RESPONSE TO PLANNING APPLICATION 17/02414/F

Thank you for consulting Mid-Cherwell Neighbourhood Plan Forum (MCNPF) on this application.

MCNPF wishes to **OBJECT** to this application. The neighbourhood plan is about to be formally submitted to Cherwell DC, and we ask therefore that the following objection be taken into account on the basis of our emerging policies.

PROJECT:	SOUTH SIDE, STEEPLE ASTON	DEPARTMENT:	PLANNING	DRAWN BY:	GL	CHECKED BY:		RECTORY LTD RECTORY HOUSE THAME ROAD HADDENHAM, AYLESBURY, BUCKINGHAMSHIRE HP17 8DA			
DRAWING:	PLOT 5 PLANS AND ELEVATIONS	DRAWING No:	P.224.DH.1801.02	SCALE:	1:100	PAPER:	A2			REV:	A
		STATUS:	PROPOSED	DATE:	28.07.17

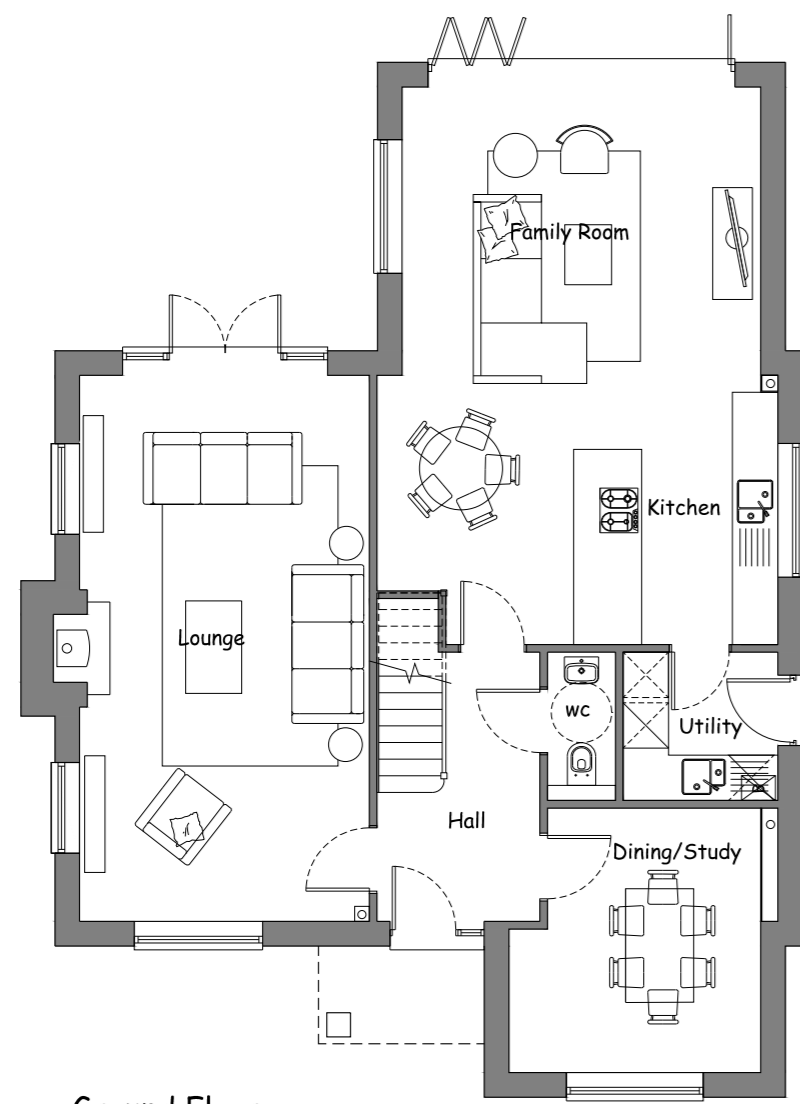
The scheme proposes six 4-bedroom houses. Application of policy PH1 would imply that of the six dwellings only 2 should be 4-bedroom, 3 should be 3-bedroom, and 1 should be 2-bedroom. Such a mix would offer more affordable homes to local people, which is a key objective of the neighbourhood plan. Evidence to support this need is contained in the Oxfordshire SHMA (table 65) and para. B123 of the CDC adopted Local Plan part 1 (and policy BCS4 which encourages negotiation on the issue of housing mix).

PROJECT: South Side, Steeple Aston			
DRAWING: Proposed Site Plan			
DEPARTMENT: Planning	DRAWN BY: GL	CHECKED BY:	
DRAWING No: P.224.SP.01	SCALE: 1:500	PAPER: A3	REV: D
STATUS: PROPOSED	DATE: 28.07.17

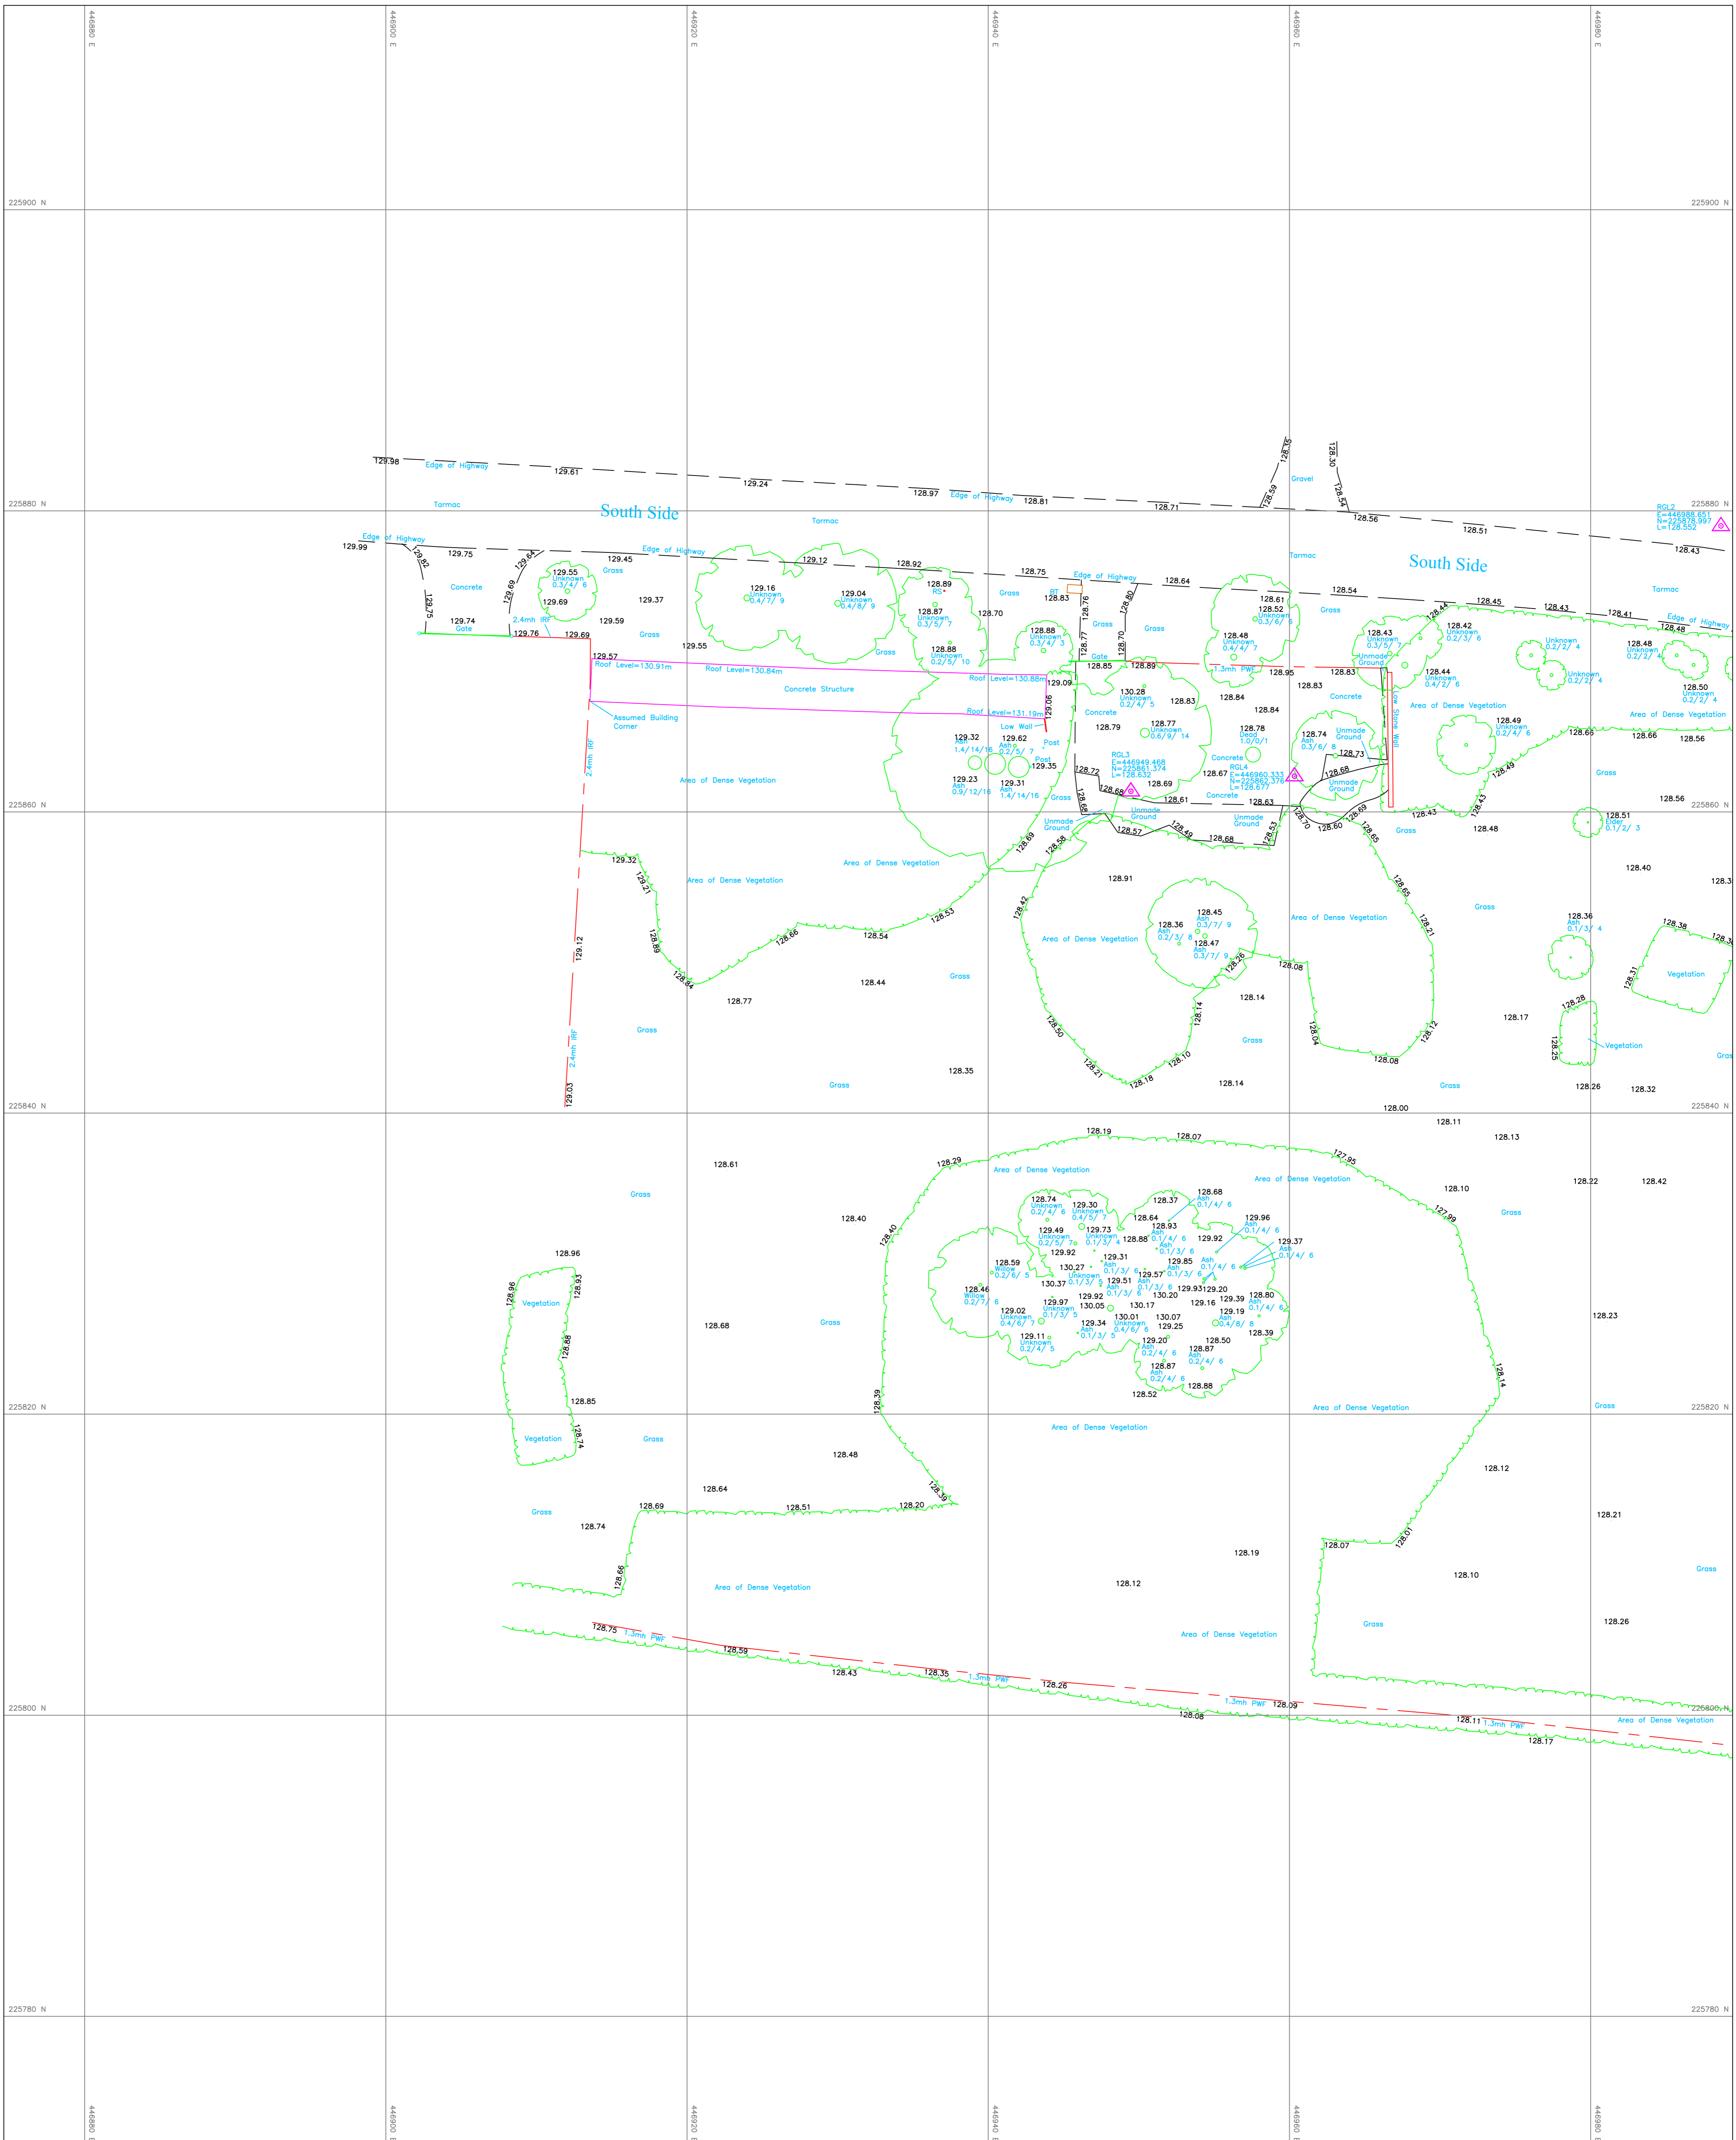
The application scheme will require pedestrians to walk in the road to access the rest of the village, which is unacceptable.
